City of Albuquerque Stormwater Construction Site Inspection Report

ESC File No.	C18E085	Project Name:	Allaso Olivine		
NPDES Id. No.	NMR10059X & '5CC	Location:	6925 Alameda Blvd NE		
10/7/2024	Owner	Contractor			
Operator	Titan Olivine, LLC		HB		
Contact name & title	Josh Rogers		Zach Gruen VP & Matthew Barnard SI		
e-mail	jrogers@titan-development.com		zachg@Hbconstruction.com & leer@		
Contact Phone #	505-998-0111		856-0404 & 250-2069		
COA Inspector	Chancellor English		Start/End Time:	3pm	
Construction Phase:	verticals/exteriors				
Type of Inspection:	Regular	Storm Event	Past Storm Event >0.25"	311/Complaint Follow Up	
Weather at time of inspection?		clear	Temperature: ~	85	
Estimated date of last storm 0.25" or greater		7/22/2024

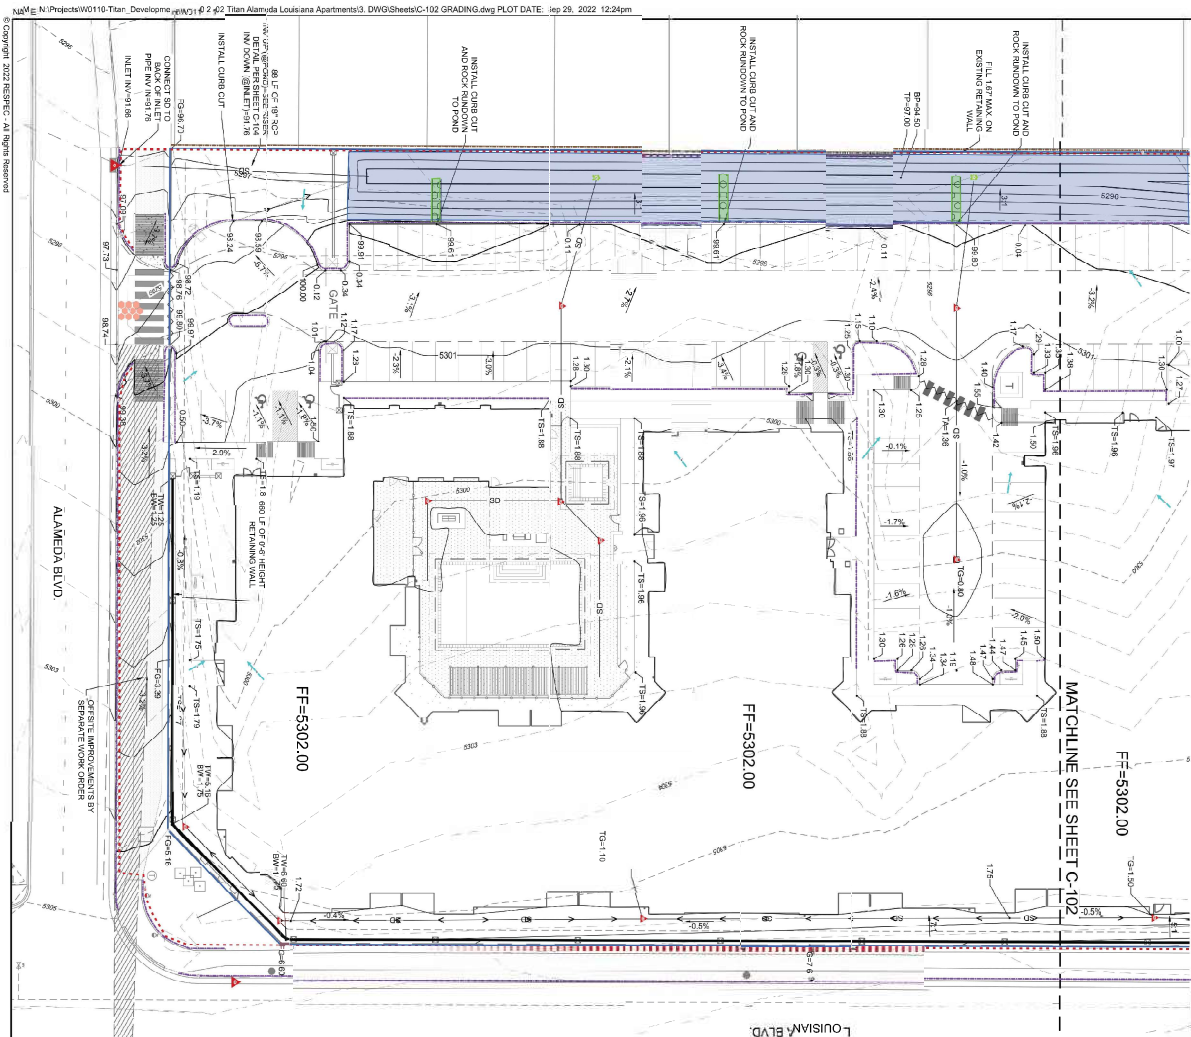
Item Number	Deficiency/ Corrective Action				
1	Washout - The washout container had leaked and deposited on bare soil in violation of CGP Part 2.3.4. Required mitigation: Direct wash water into a leak-proof container or leak-proof and lined pit designed so no overflows can occur due to inadequate sizing or precipitation. Do not allow liquid wastes to be disposed of through infiltration or to otherwise be disposed of on the ground per CGP Part 2.3.4.				
2					
3
